# PLANNING AMENDMENT

Application No. A09/0668/02

Steel Framed  
Building

**Re: PROPOSED STEEL FRAMED BUILDING**

Council Offices
 Priory Road
 Spalding
 Lincolnshire
 PE11 2XE

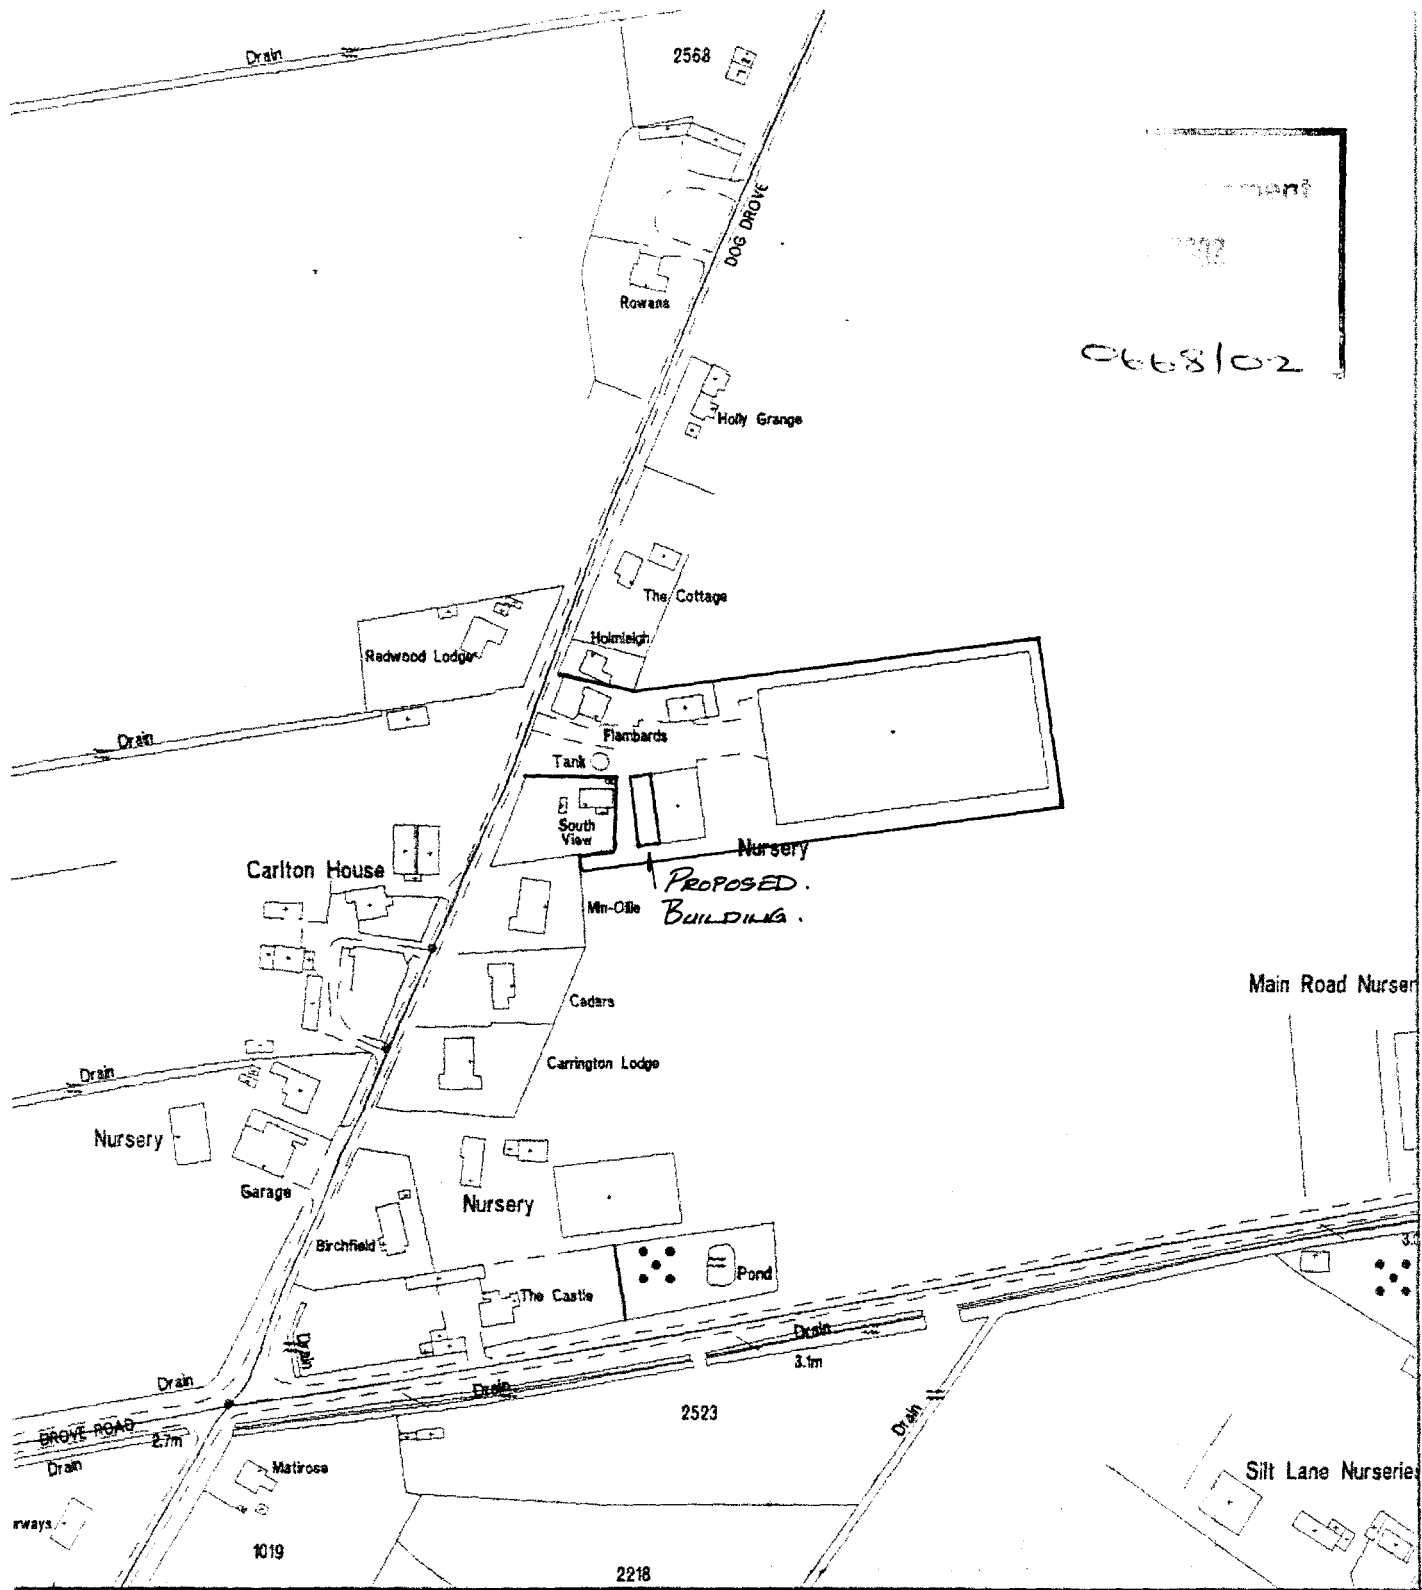
Composite  
Sheeting to  
north + west  
elevations

4No COPIES OF REVISED DRAWING E6380/D1 REVA , REGARDING PROPOSED COPOSITE SHEETING TO NORTH AND WEST ELEVATIONS AS REQUESTED IN YOUR LETTER DATED 14 AUGUST 02.
